Rezoning Transportation Analysis
Petition Number: Insert Zoning Petition #2021-045
General Location Identifier: Tax ID 02918118

Revision Log:	Date	Description
	04-29-21	First Review (EL)
	05-27-21	Second Review (EL)

REZONING PETITION #2021-045
FOR
MALLARD CREEK APARTMENTS
CHARLOTTE, NORTH CAROLINA

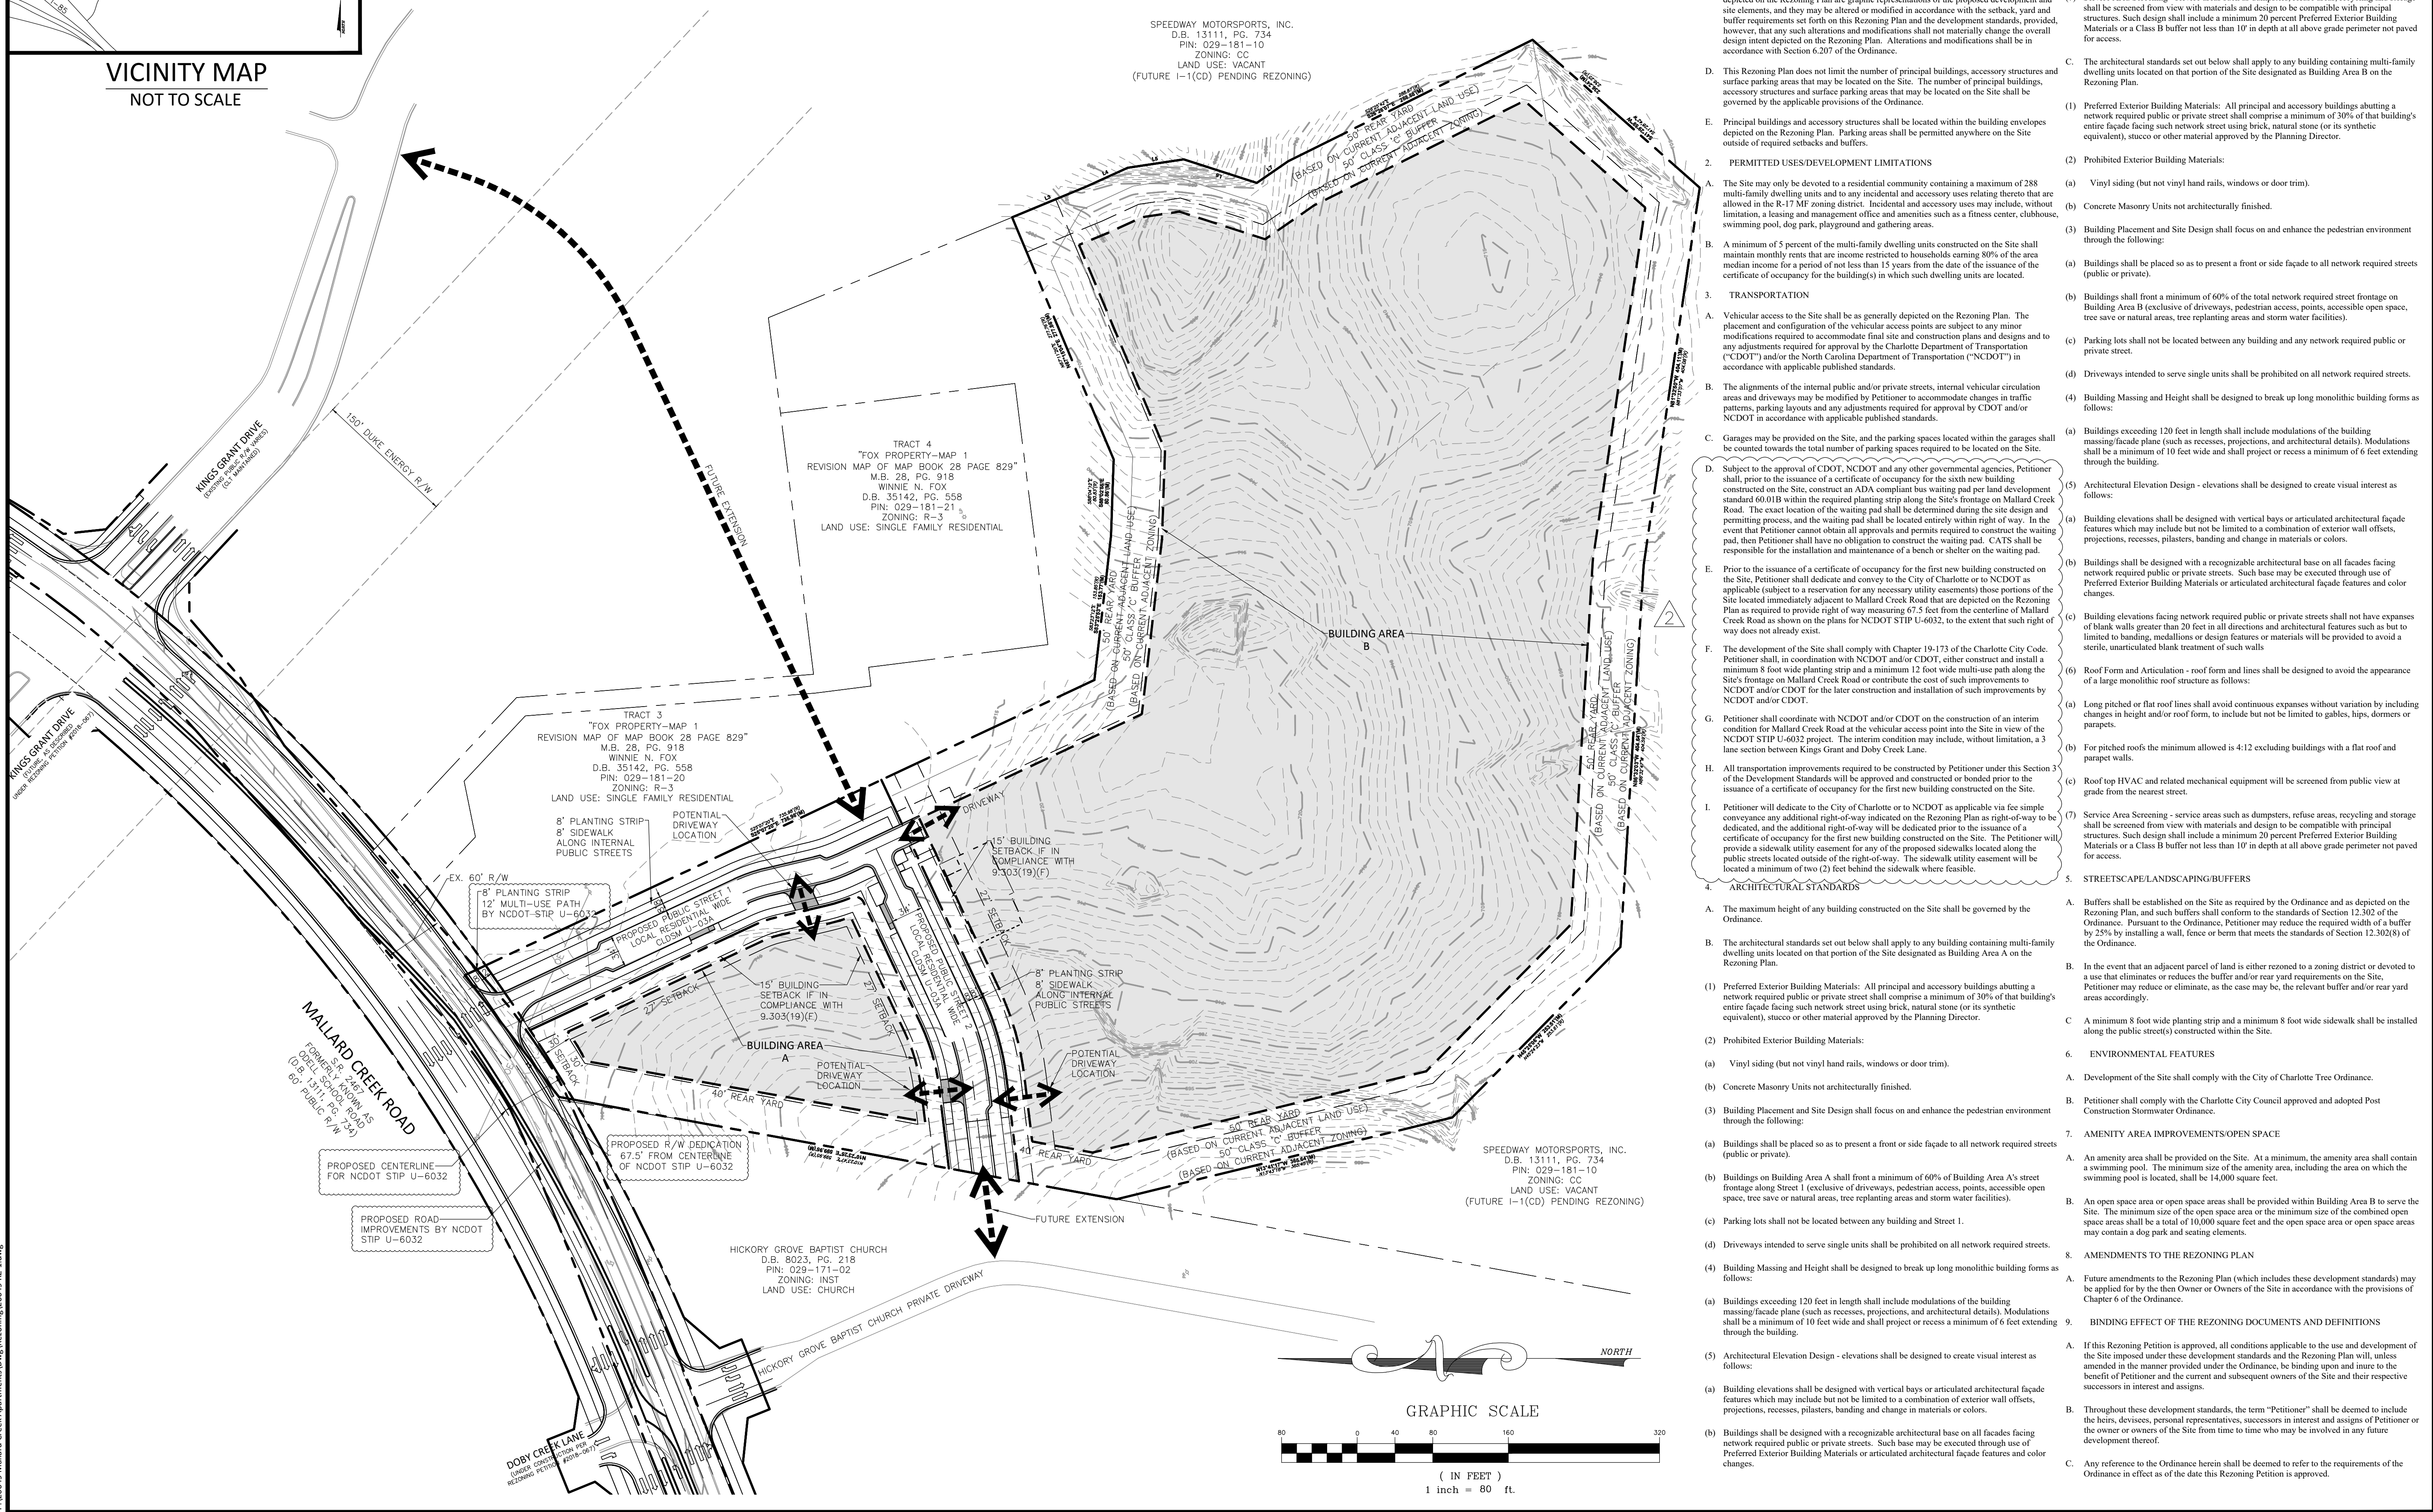
7. **Update to comment (site plan dated 2021-05-17):** Revise the conditional note below to specify that all right-of-way will be dedicated prior to the first building CO. A site plan note(s) specifying dedication and fee simple conveyance of all rights-of-way to the City before the site's first building certificate of occupancy is issued is needed. CDOT requests rights-of-way set at 2' behind back of sidewalk where feasible.

8. **Update to comment (site plan dated 2021-05-17):** Revise all required improvements to be constructed prior to first CO, unless a phasing plan is provided to CDOT for review and approval. A site plan note specifying that all transportation improvements will be approved and constructed before the site's first building certificate of occupancy is issued is needed. The petitioner may phase transportation improvements if said improvements and phasing are explicitly described in site plan notes.

9. **New comment (site plan dated 2021-05-17):** Replace all conditional note references regarding a permanent sidewalk easement to a sidewalk utility easement.

E. Prior to the issuance of a certificate of occupancy for the ~~sixth new building~~ **first** constructed on the Site, Petitioner shall dedicate and convey to the City of Charlotte or to NCDOT as applicable (subject to a reservation for any necessary utility easements) those portions of the Site located immediately adjacent to Mallard Creek Road that are depicted on the Rezoning Plan as required to provide right of way measuring 67.5 feet from the centerline of Mallard Creek Road as shown on the plans for NCDOT STIP U-6032, to the extent that such right of way does not already exist.

H. All transportation improvements required to be constructed by Petitioner under this Section 3 of the Development Standards will be approved and constructed or bonded prior to the issuance of a certificate of occupancy for the ~~sixth new building~~ **first** constructed on the Site.

I. Petitioner will dedicate to the City of Charlotte or to NCDOT as applicable via fee simple conveyance any additional right-of-way indicated on the Rezoning Plan as right-of-way to be dedicated, and the additional right-of-way will be dedicated prior to the issuance of a certificate of occupancy for the first new building constructed on the Site. The Petitioner will provide a permanent sidewalk easement for any of the proposed sidewalks located along the public streets located outside of the right-of-way. The permanent sidewalk easement will be located a ~~minimum of two (2) feet~~ behind the sidewalk where feasible.
